Town & Country Planning Act 1990 (as amended)
Town and Country Planning (Development Management Procedure) (England) Order 2015
Approval of matters reserved by condition imposed under A/27/16/PL relating to conditions 7-
Construction Management Plan & 19-Tree Protection Measures.
Broadlees Dappers Lane, Angmering,

Arun District Council have decided to **REFUSE details reserved by condition for the following reasons:**

TREE PROTECTION (Plan 3A)

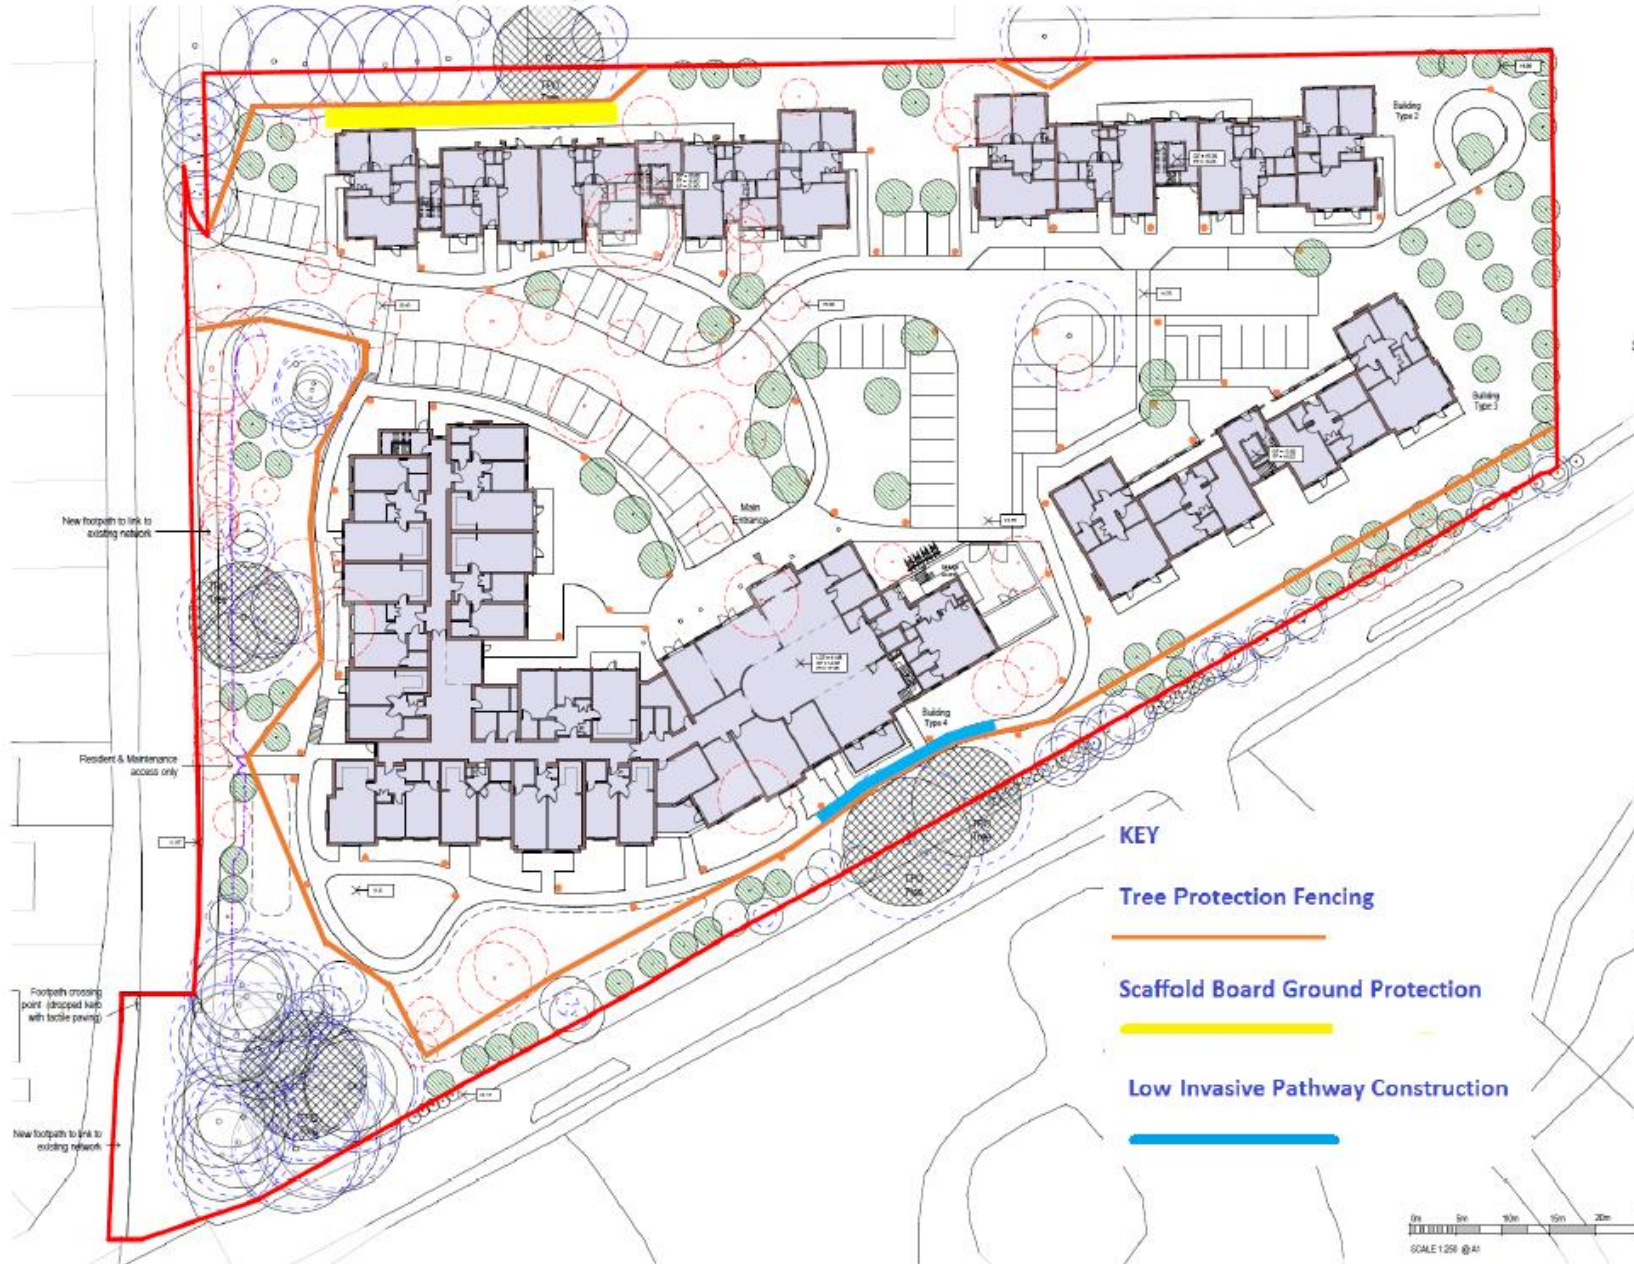
The provision (and subsequent agreement by the LPA) of a suitable Tree Protection Plan (TPP) is not itself sufficient to discharge the condition. In the absence of general vegetation clearance and erection of Protective Fencing the condition has not been complied with and cannot be

Any tree protection measures must be in place before heavy plant access, soil movement, demolition or construction occurs. The prior installation of an effective "Construction Exclusion Zone" and any specified ground protection measures must be inspected by and be to the satisfaction of the LPA (Tree Officer) before the appropriate condition can be discharged. Anything less and we are facilitating the occurrence of potentially irreversible damage to those trees identified for retention
